Application Number: 2013-056 **Application Date:** 02/26/2013
CBL: 316 A00500B *316-A-11* **Application Type:** Level II Site Plan
Project Name: Parking Lot Expansion
Address: 741 Warren Avenue
Project Description: Parking lot that will create approx. 13,207 sq. ft. of impervious area and 17,078 sq. ft. of landscaped area.
Zoning: IM *- yes*

MEMORANDUM

Subject: Application ID: 2013-056

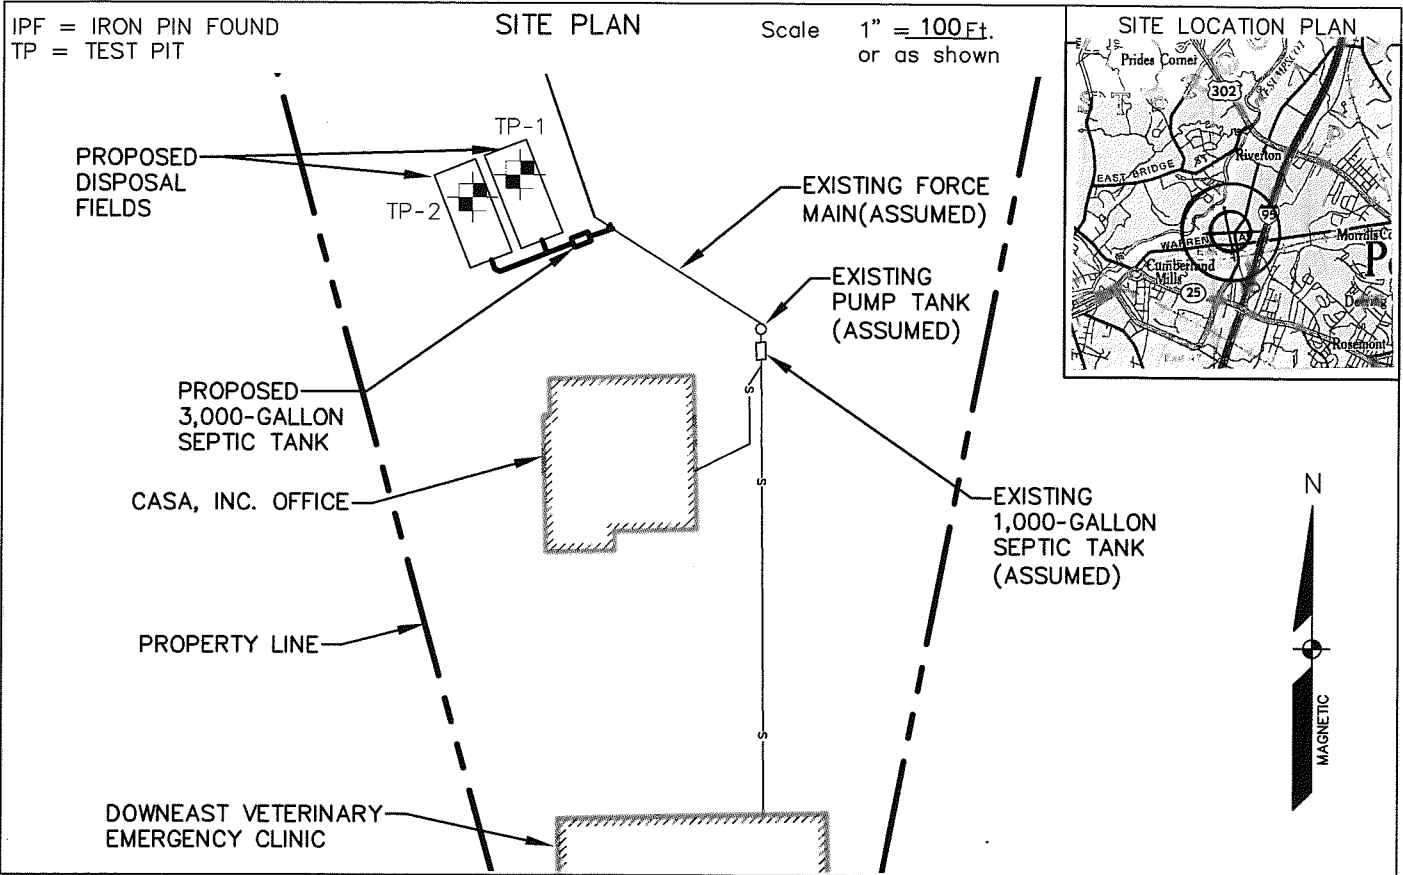
Section 14-250(h) of the I-M zone requires a minimum 10' pavement setback from property lines. The plans are showing a 6' pavement setback which is in violation of the I-M zone requirements.

The revised plans after our group meeting on 3/20/2013 show a reduction of parking spaces. The new plans show that there is approximately 65' from the edge of pavement and the property line. The Zoning Ordinance only requires a minimum of a 10 foot setback of pavement. This project is more than meeting the minimum pavement setback.

The revised plans showing the most current reiteration of the proposal. The 10' minimum setback for pavement is still being met on this plan. I scaled about a 12' setback. This project is meeting the I-M zone requirements.
